Advice on Environmental Impact Statement – State Significant Development

Proposal: Taronga Zoo Sky Safari

Major Project reference: SSD-46807958

Figure 26 Top Station Location Plan

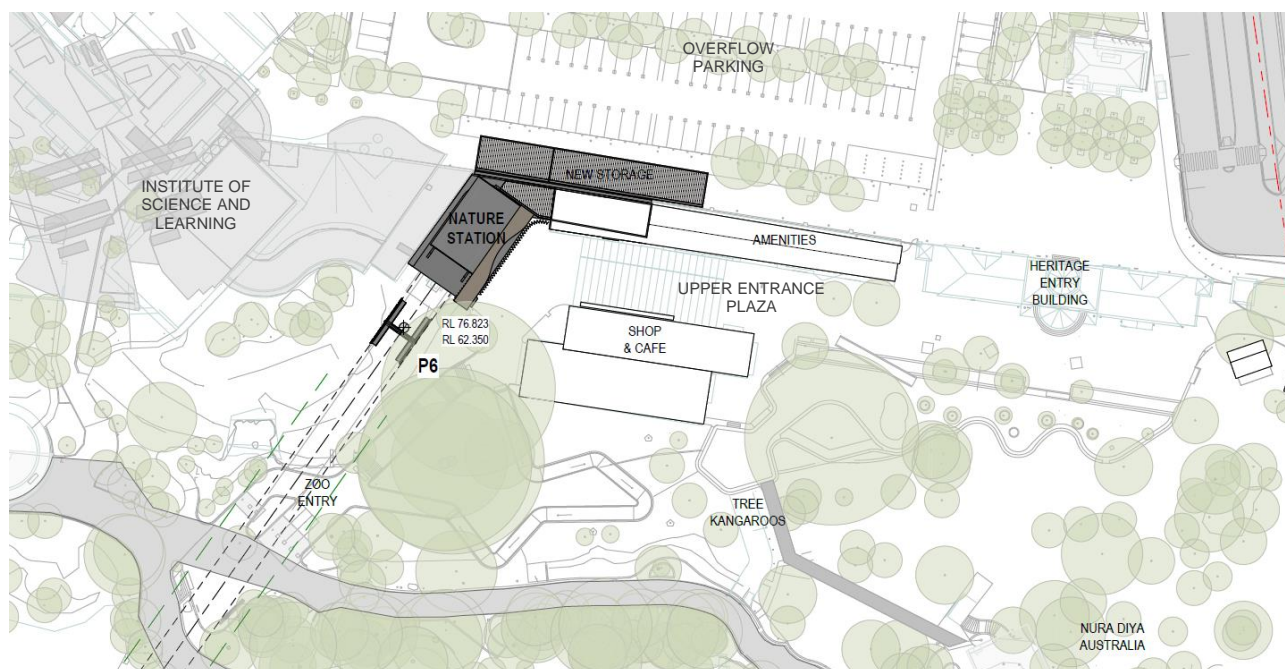
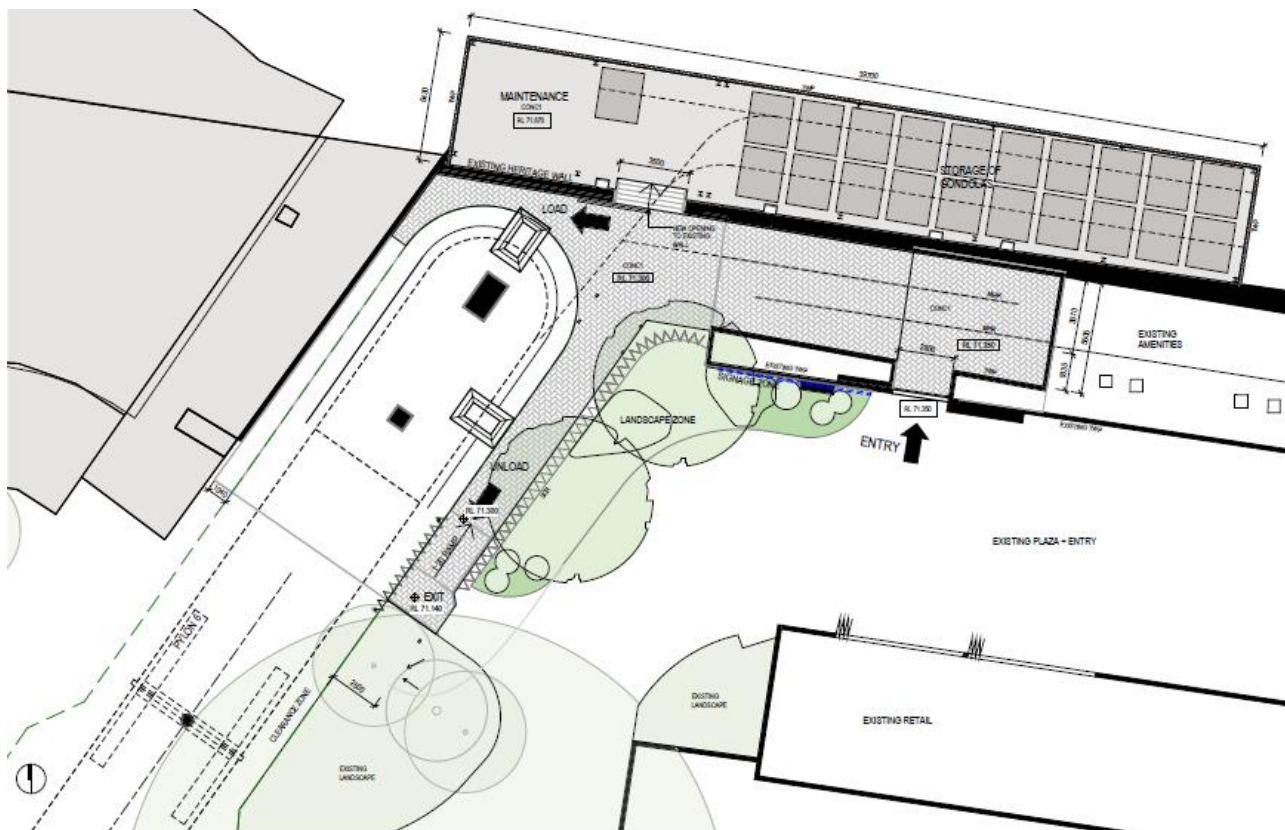
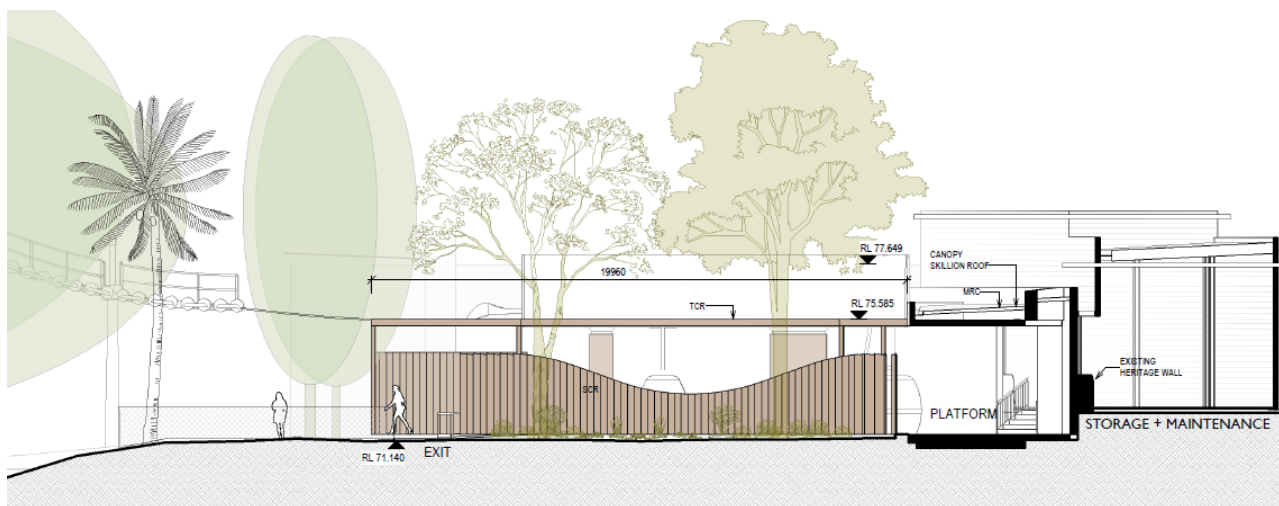
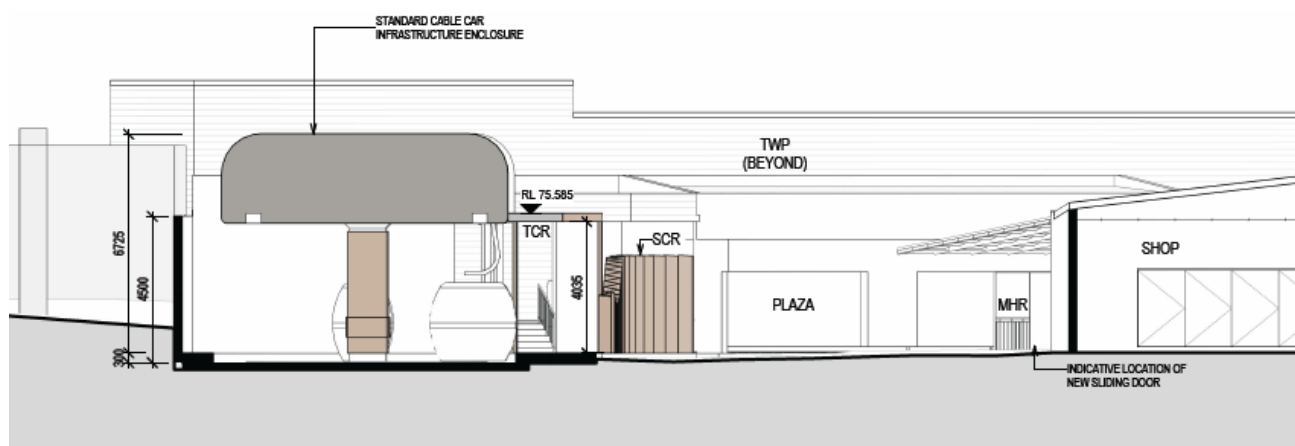
- The Heritage Impact Statement (HIS) has assessed that the heritage impacts of the proposal are acceptable. Heritage NSW generally supports this assessment but have concerns regarding the potential heritage impacts of the proposed Maintenance and Storage Building (MSB). The MSB would be located outside of the zoo's perimeter wall in the vicinity of the zoo's main entrance. It would enclose part the perimeter stone wall, which is listed on the zoo's Section 170 Heritage and Conservation Register. We consider that there is a risk that the MSB would detract from the external presentation of the zoo and potentially cause damage to the perimeter stone wall. We would appreciate an opportunity to review and comment on the detailed design of the MSB and have made recommendations in this regard in Attachment A.

- f) The detailed design of the Maintenance and Storage Building (MSB) should be submitted to Heritage NSW for review and comment. The detailed design should demonstrate:

- that options to minimise the overall dimensions of the MSB have been considered.
 - that the facade treatment is appropriate to its context as external to the zoo perimeter wall.

- that consideration has been given to reducing the perceived scale of the building through facade treatment or other means such as landscaping.
 - that the detailing of the MSB at the junction with the stone wall appropriately acknowledges the stone wall as a historic marker of the zoo's perimeter.

- that the MSB is structurally independent of the stone wall, and that it will not impact on the structural integrity of the wall including any proposed footings.

- provision for any measures to stabilise, strengthen or protect the stone wall, particularly in the location of the proposed new opening.
 - that the MSB would be 'reversible' and could be removed in the future without damaging the heritage stone wall.

- g) The proposed new opening in the northern perimeter stone wall should be constructed by an experienced heritage stonemason.
